**KIRKLEES METROPOLITAN COUNCIL
INVESTMENT & REGENERATION SERVICE**

DELEGATED DECISION TO DETERMINE PLANNING APPLICATIONS

Reference No:	2024/62/90786/W
Site Address:	21, Woodhead Road, Lockwood, Huddersfield, HD4 6ER
Description:	Erection of porch
Recommending Officer:	Joanna Rednall

HOUSEHOLDER DELEGATED REPORT

South East Elevation

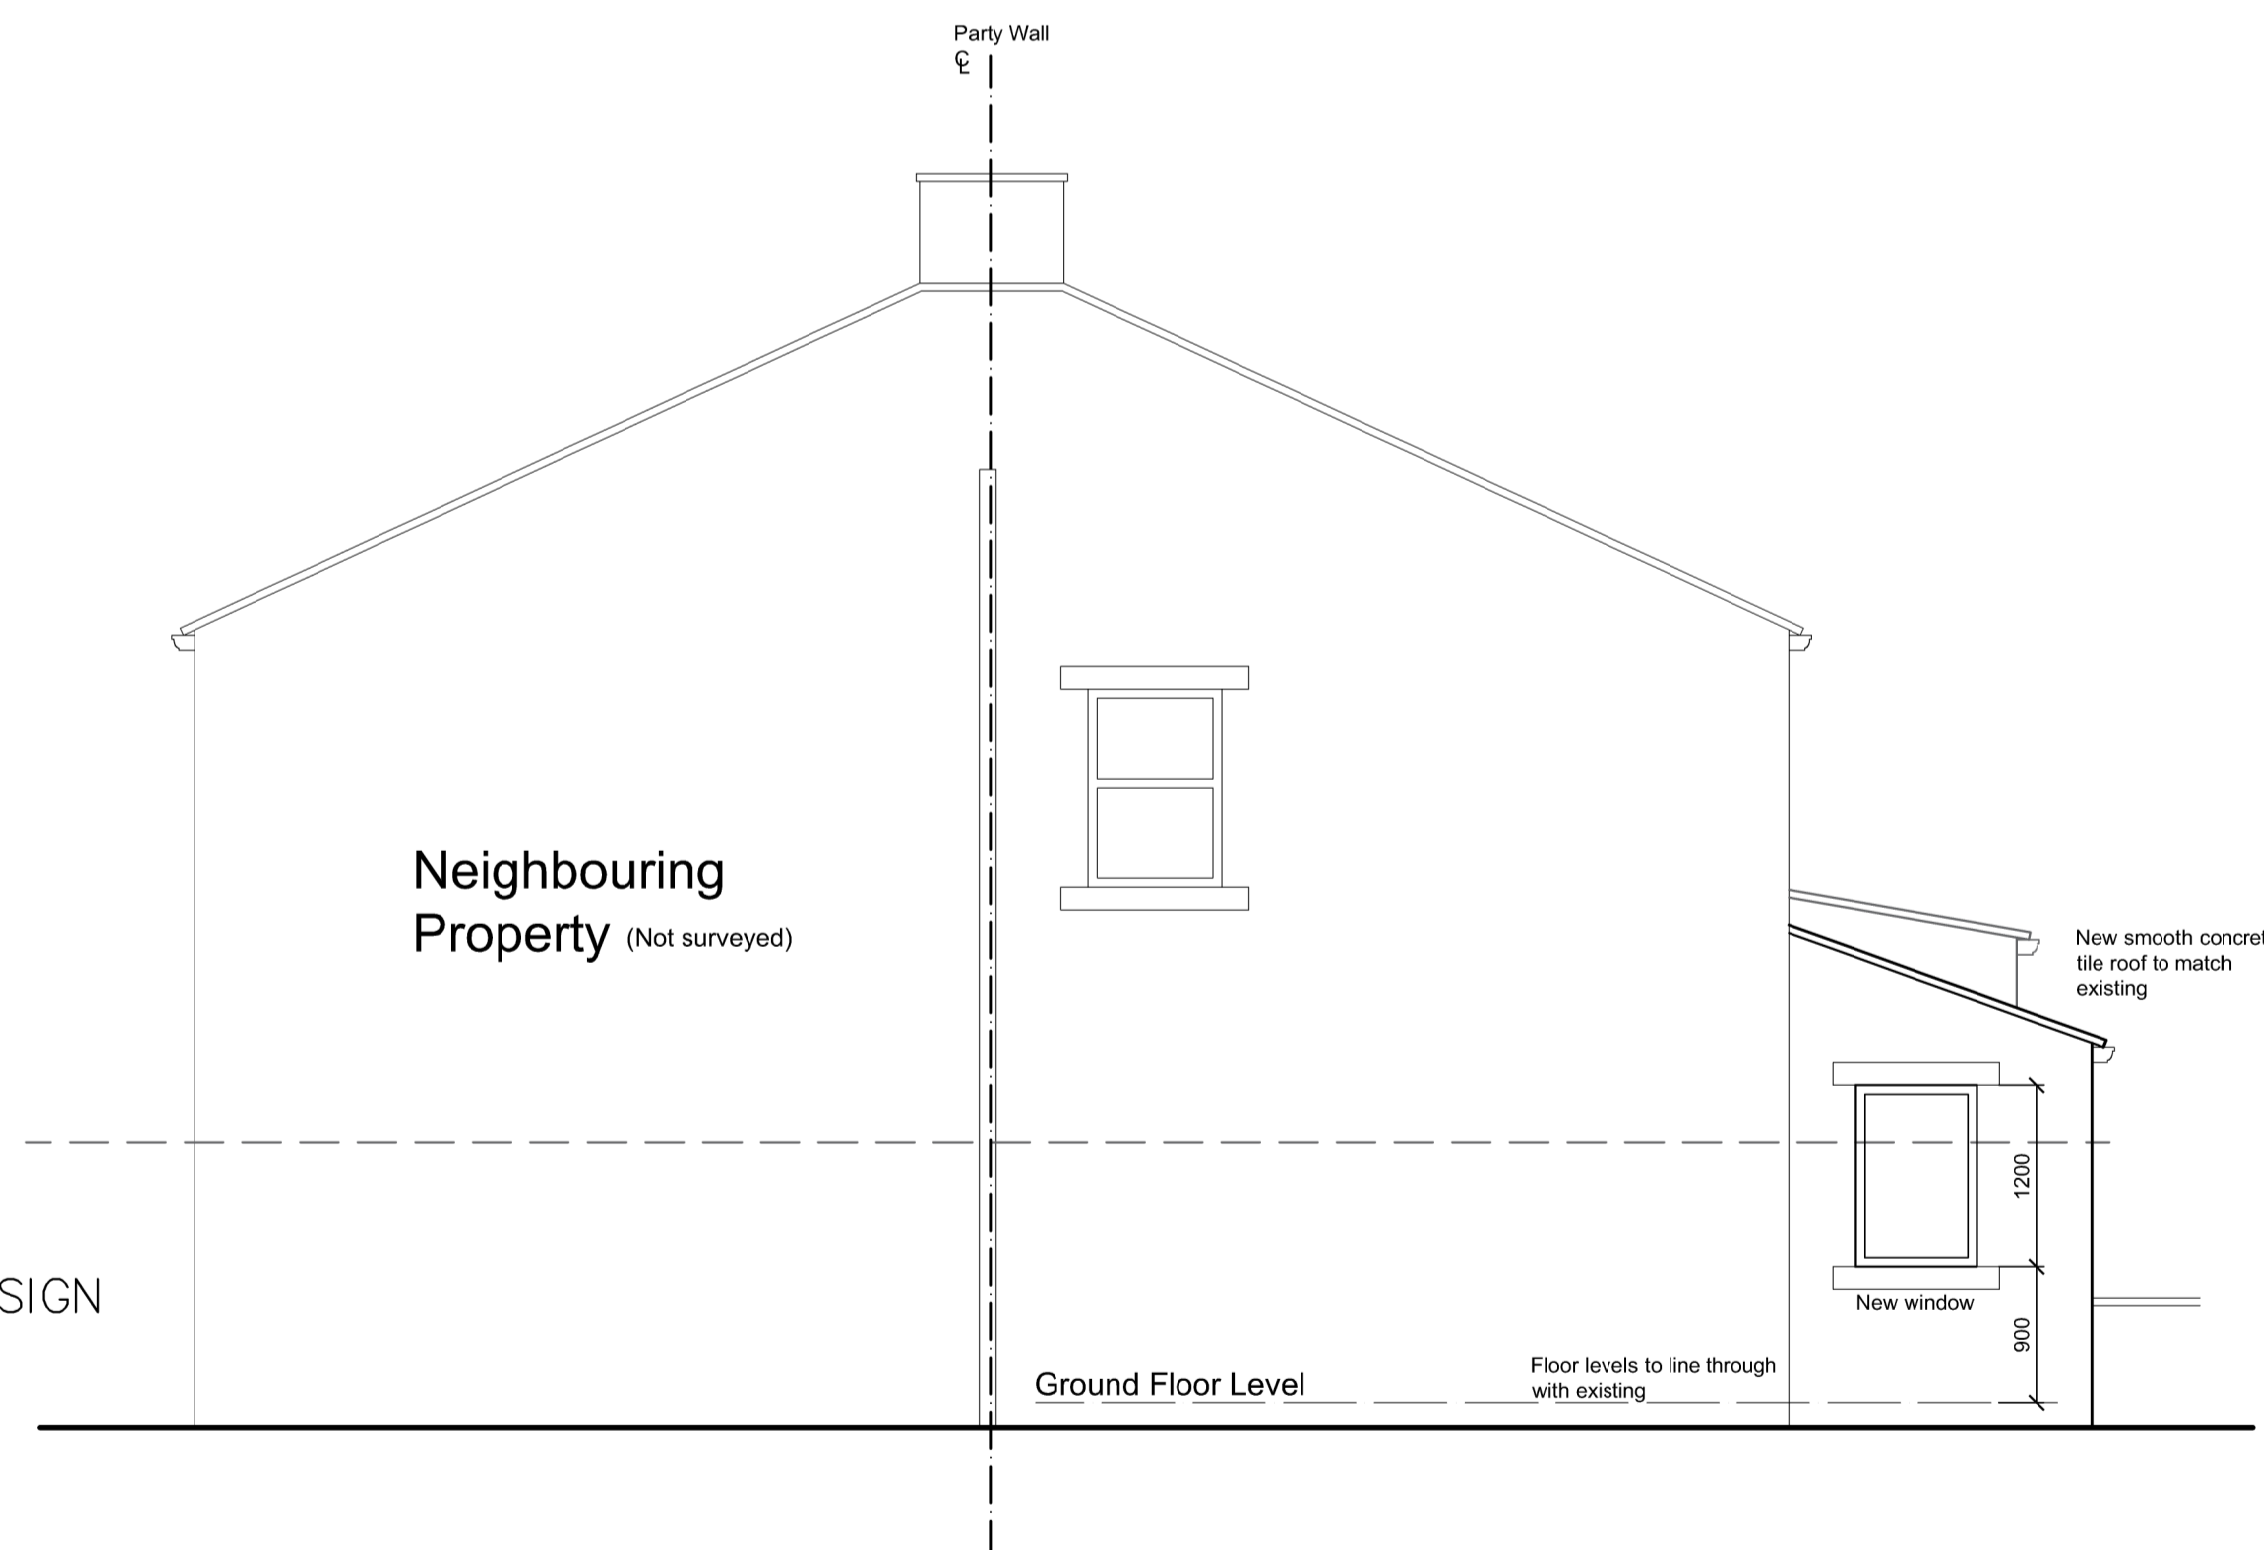
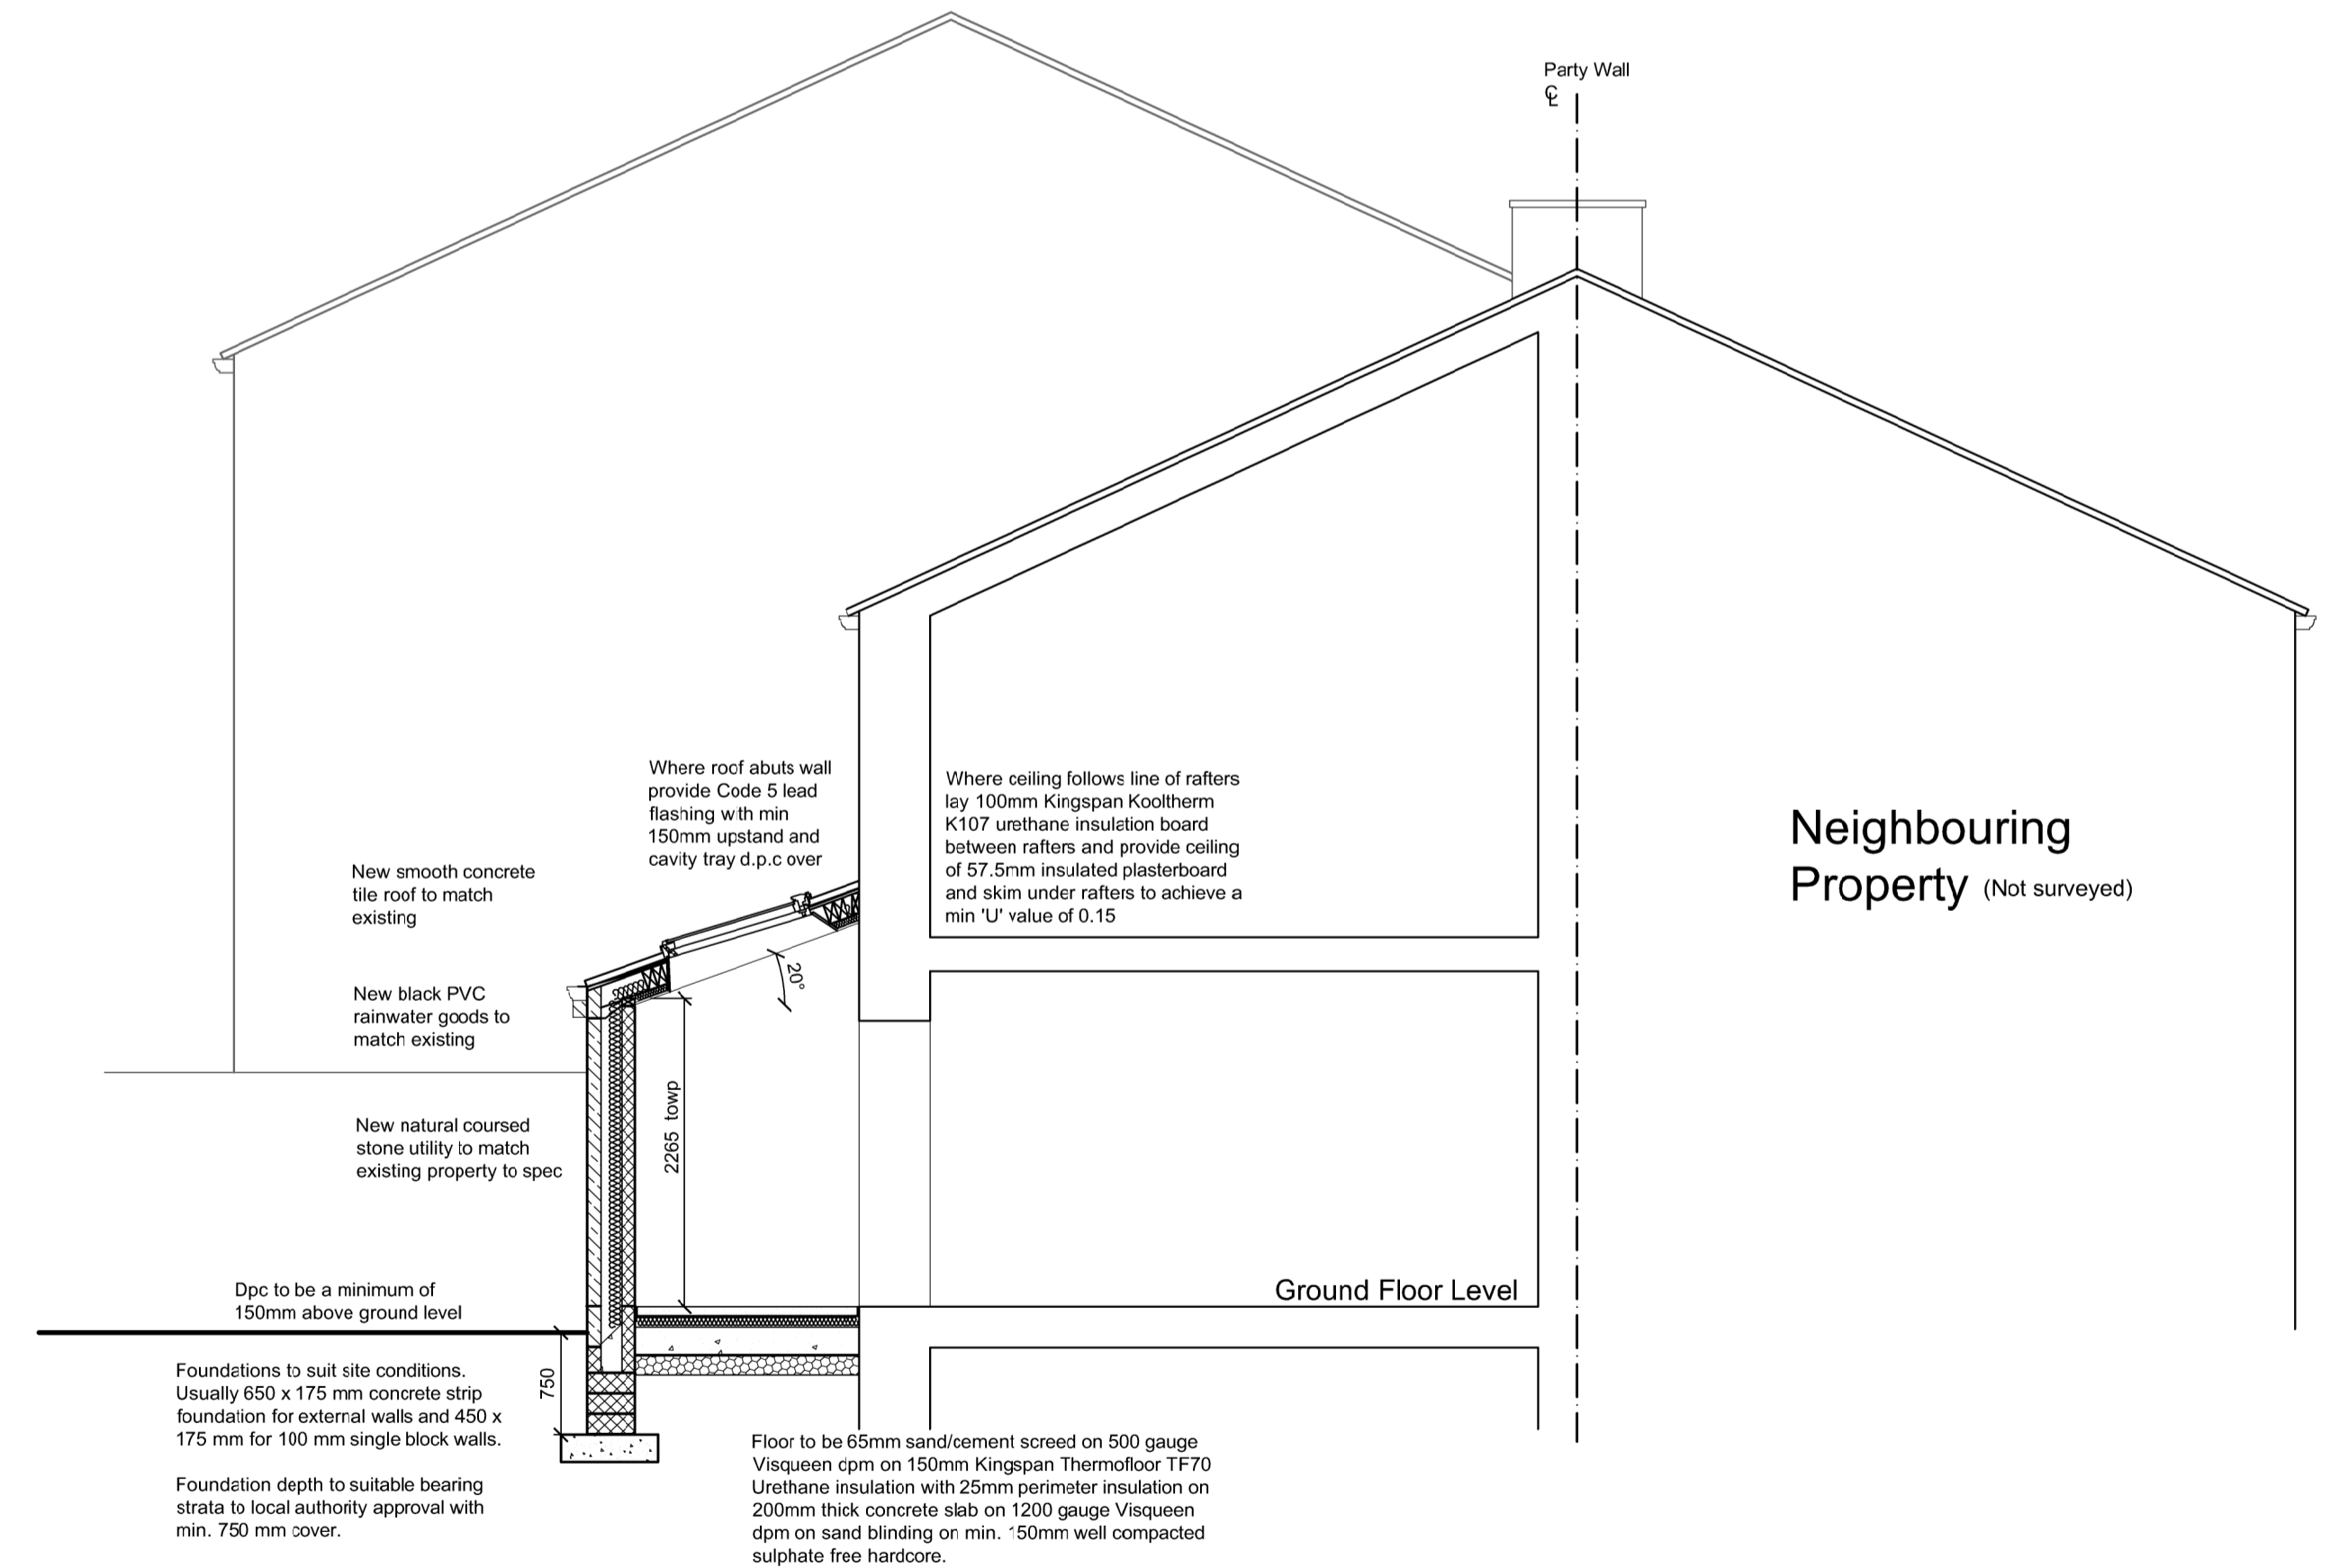
The measurements of the porch would be as follows:

- ~2 metre projection
- ~2.7 metre width
- ~2.5 metre eave height
- ~3.3 metre ridge height

The proposed construction materials are natural stone for the walls with concrete tiles for the lean-to roof.

There would be one Velux rooflight as well as one window within the south-west facing elevation.

It is not considered that the proposed works would cause detrimental harm to the residential amenities of this neighbour. The porch would be set ~3 metres off the shared boundary with blank elevation facing this neighbour, therefore would not be detrimental in terms of overlooking/overbearing/ loss of privacy.
